**Application DC/23/01457**

**Manor Cottage, Half Moon St. IP30 0RH**

**Additional Submission of Mitigating Circumstances . 18<sup>th</sup>  
May 2023.**

**Adding – Lowering roof levels - Dwg’s 4B & 4C- Elevation  
to Half Moon St. & Essential Context.**

Drawing: HM-73sec.04-C

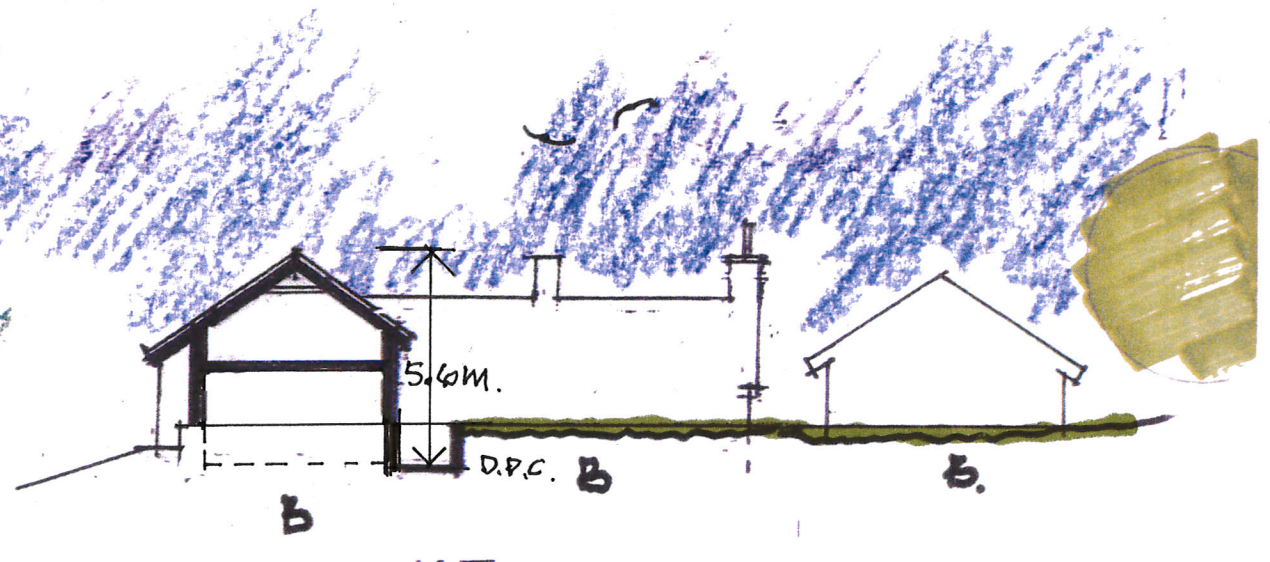
It appears that there were inconsistencies between the approved elevations as to the ridge height and roof form of the southern extension to Dwelling B. Consequently, the height of this extension was shown lower on the west and east elevations than on the south gable elevation. In principle, I consider that the taller this element is, the more likely it is to dominate/be intrusive within the setting of Manor Cottage (Grade II) as well as views out of and into the Conservation Area and the latter may also affect other heritage assets within the Conservation Area and thus cause more harm, particularly given the ground level changes. However, it is unclear what extension height has been approved.

The current application appears to seek to correct the approved drawings by consistently showing the height of this extension as reflecting that previously shown on the south gable elevation, now across all elevations. Therefore, the extension would remain no higher than has potentially already been approved. Nonetheless, particularly on the revised west elevation, the extension now appears higher than as shown on the south gable elevation, despite the measurements provided, and thus possibly the drawings are now inconsistent in the other direction (though it is difficult to accurately

measure from the drawings provided). I would therefore at least request that this is suitably addressed or clarified, so it is clear that the amended extension would not be higher than all previously approved drawings (unless the Local Planning Authority are satisfied that this is already the case). There also appears to be some design changes to the exterior of the new dwellings, alongside revisions to the access/driveway. Nonetheless, in the circumstances these are not considered to discernibly cause any additional harm.

**Dwg. 4C** – This elevation encompasses both the original approved ridge height in 2022. The roof is now designed as a mansard roof form with a 150cm high container of green planting over the flat roof areas of Sedum Grass seeds. The planting will include at the edges where planting is meeting pantiles - trailing plants & grasses etc.  
This produces a finalised part Ridge height of 5.0M
